February 14, 2019

RE: **APS Montgomery Complex** 3315 Louisiana Blvd NE Request for Certificate of Occupancy - Permanent **Engineer's Certification – Not Accepted Grading Plan Stamp Date 4/25/17 Engineer's Certification Date: 2/8/19**

Hydrology File: G18D048

HEADWALL TRASH RACK DETAIL

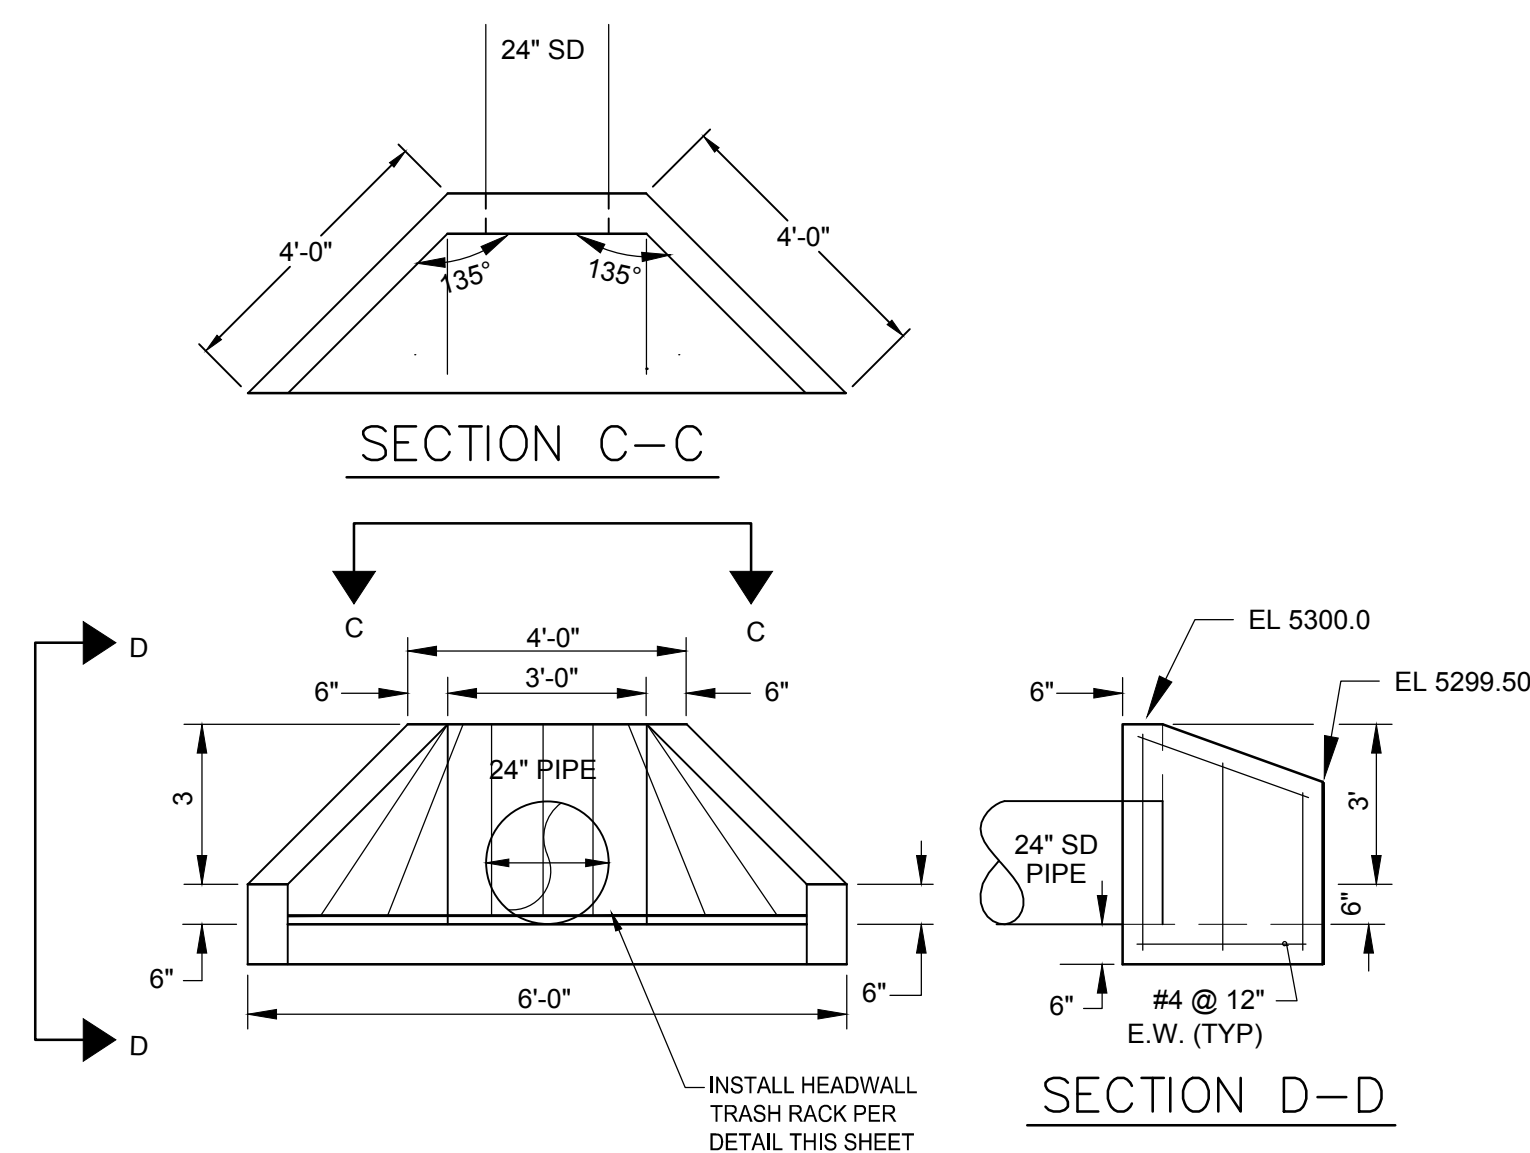
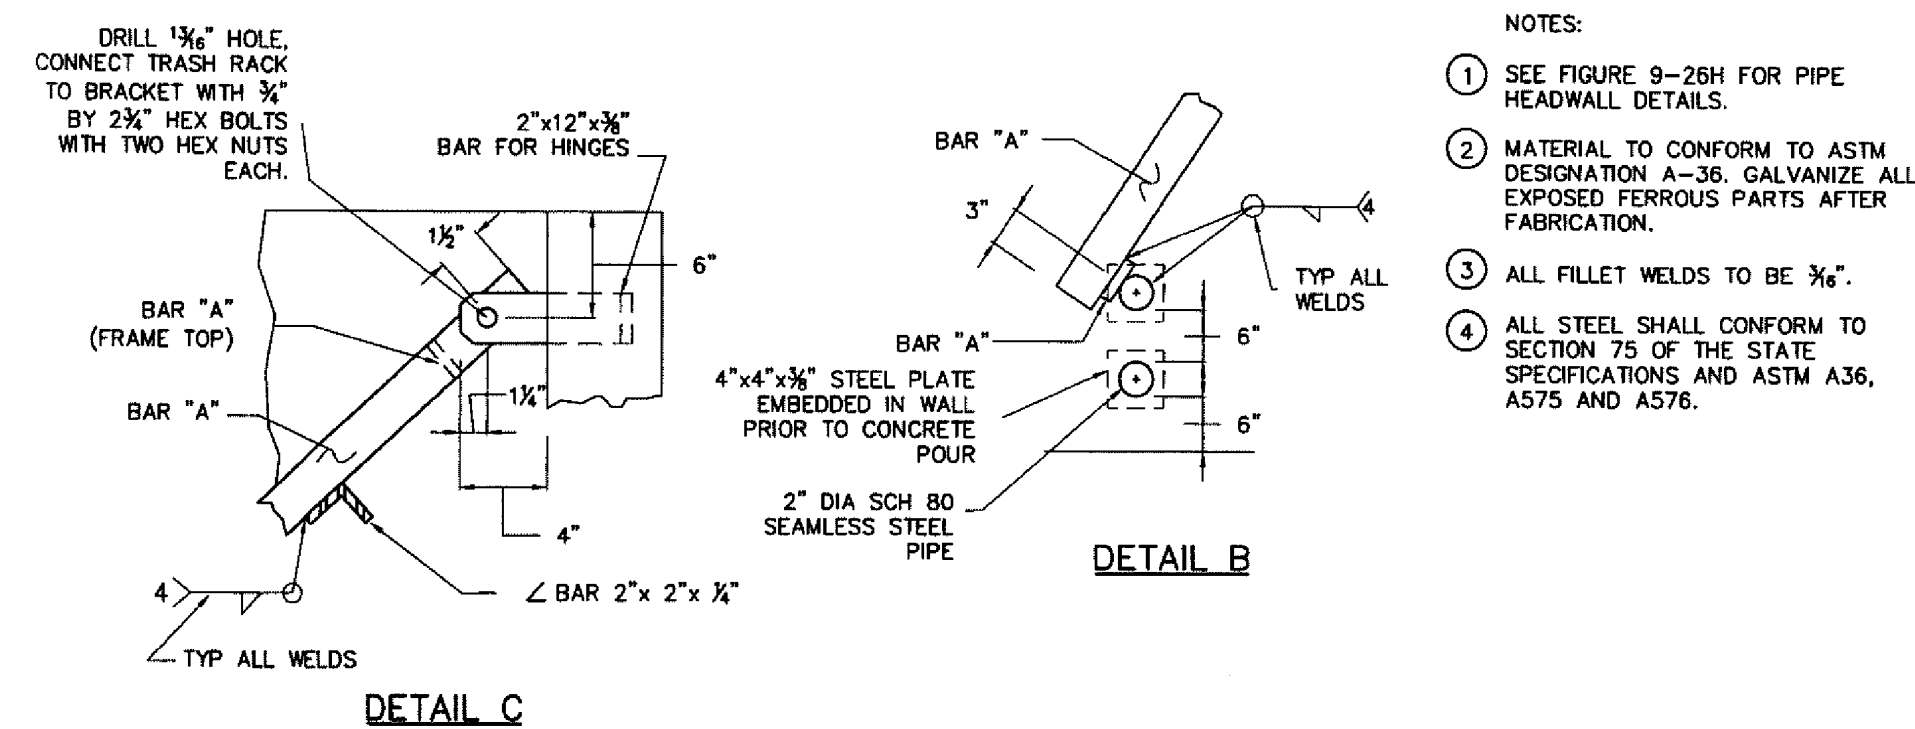
2. The headwall with trashrack in Pond 4 is missing.

OVERALL GRADING & DRAINAGE PLAN

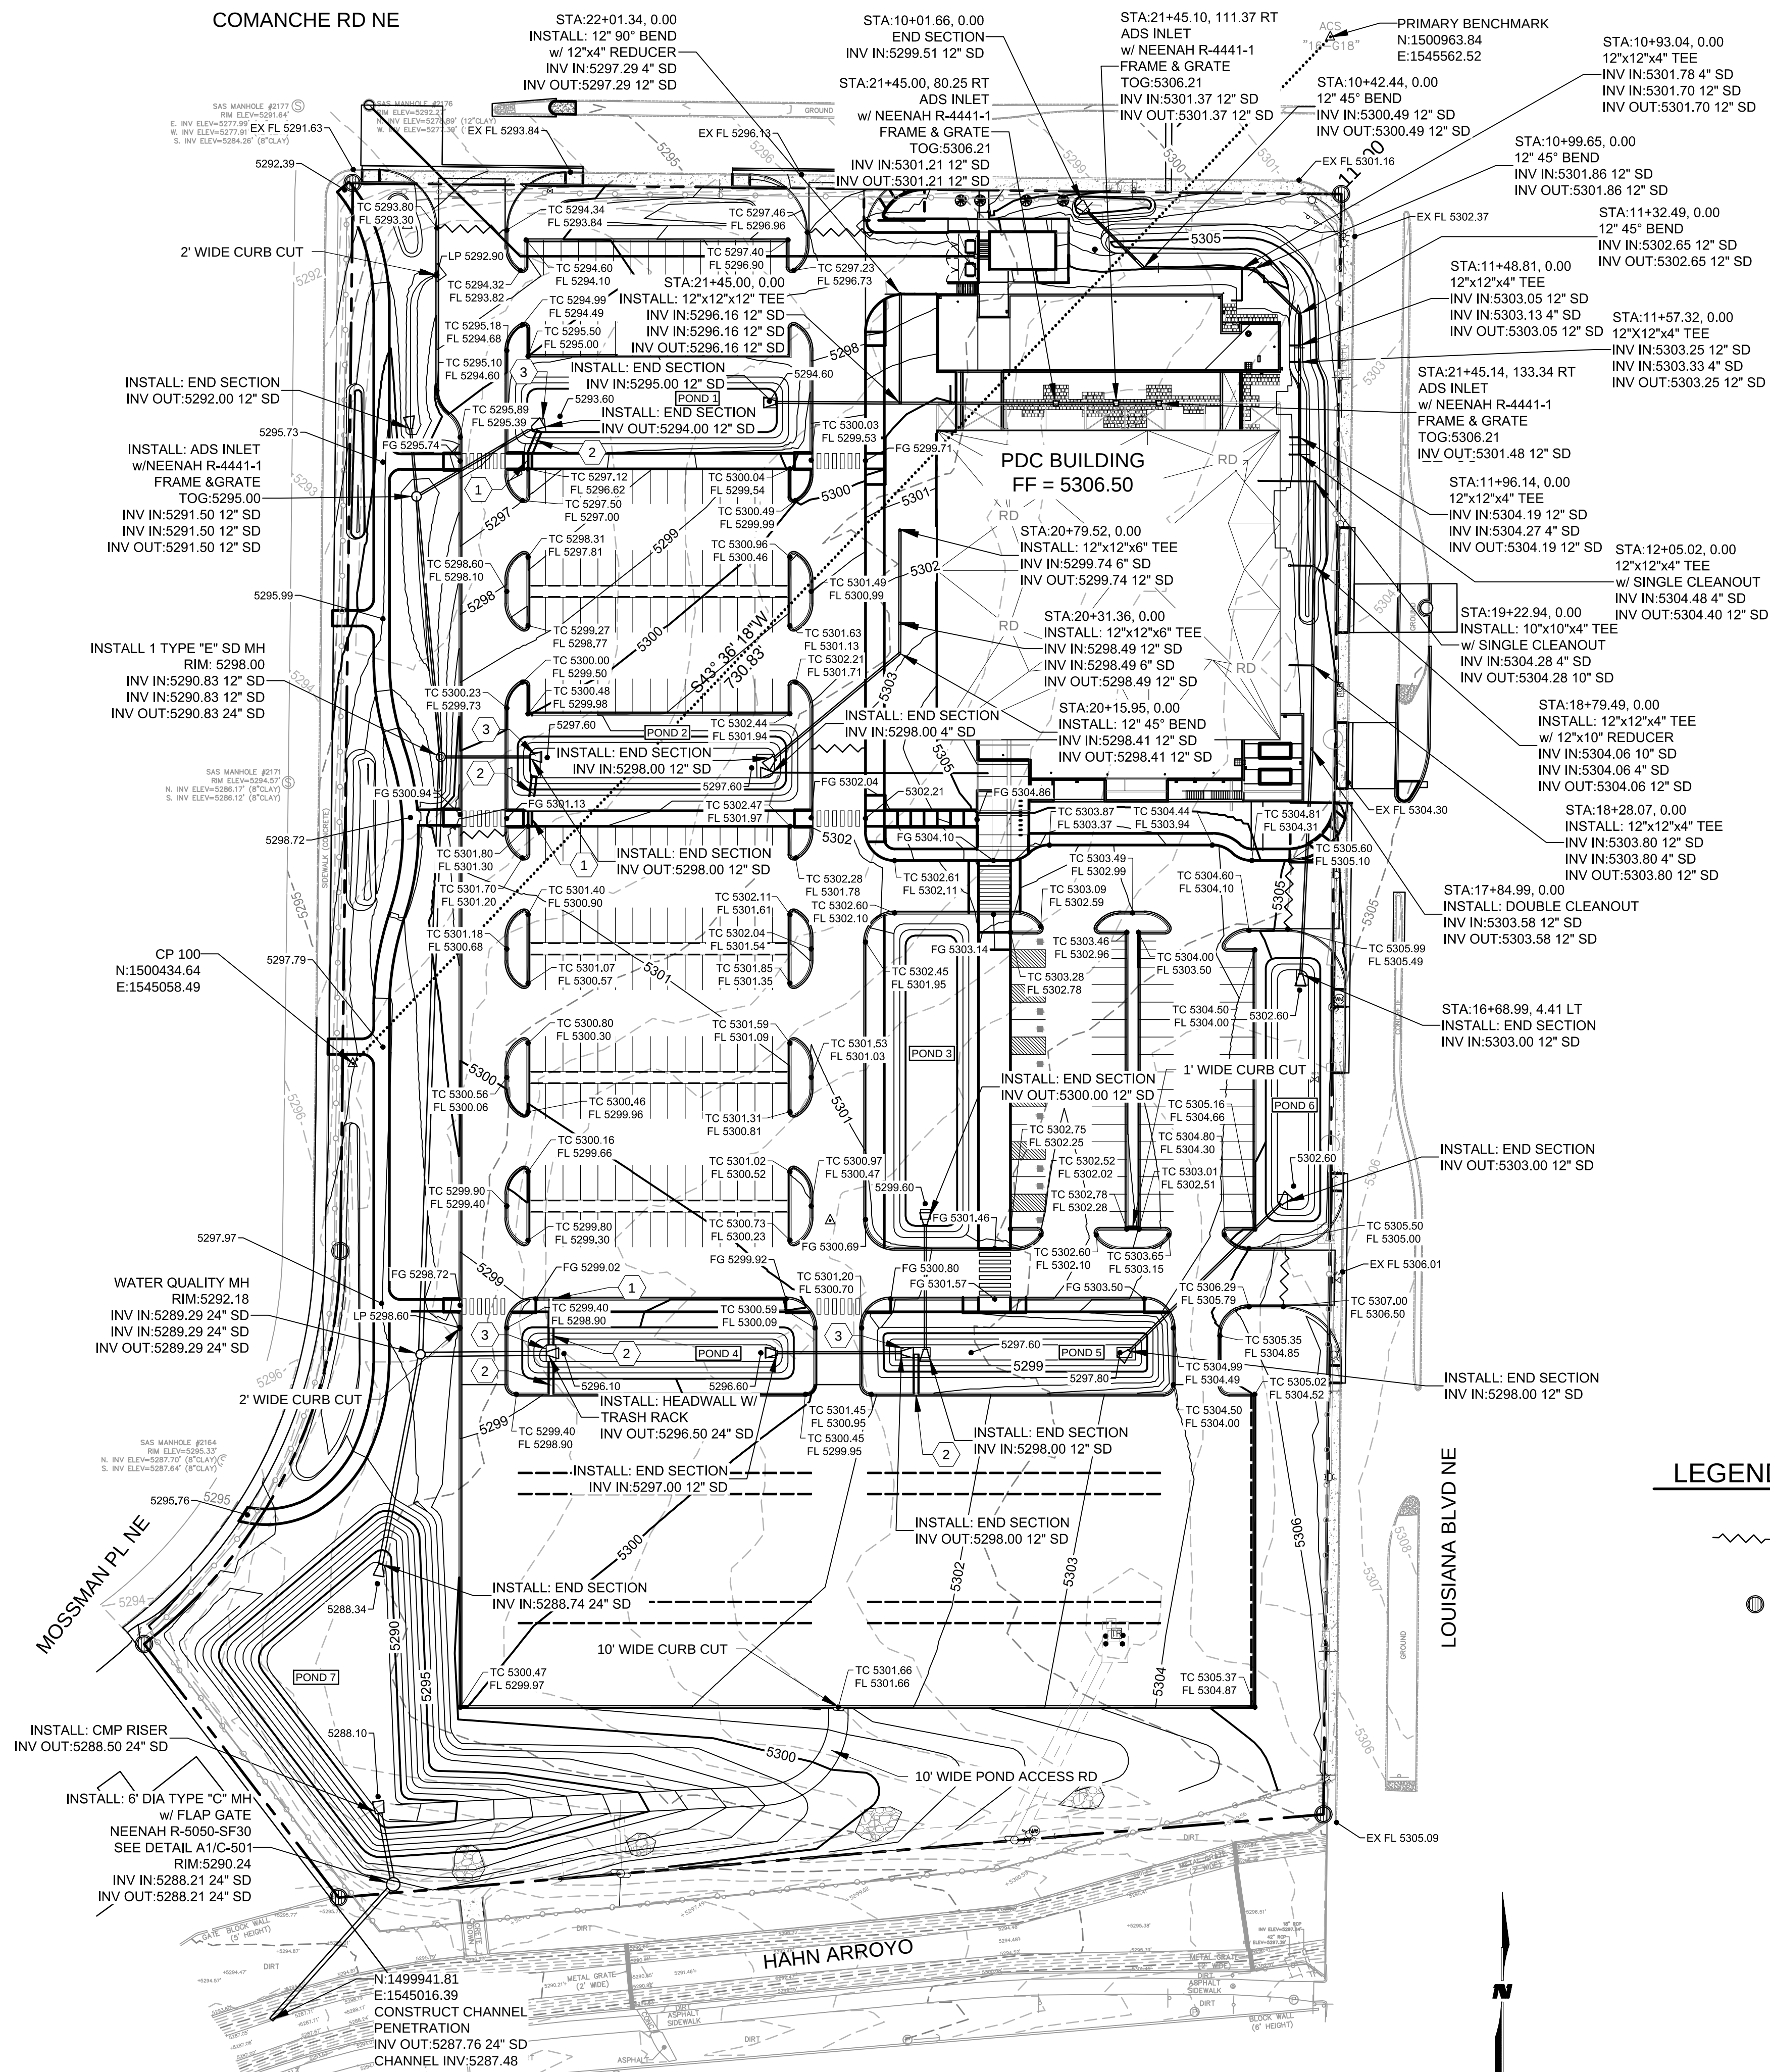
3. Provide erosion protection around the roof drain outfall on the north side of the building, 6" riprap over geotextile or similar.
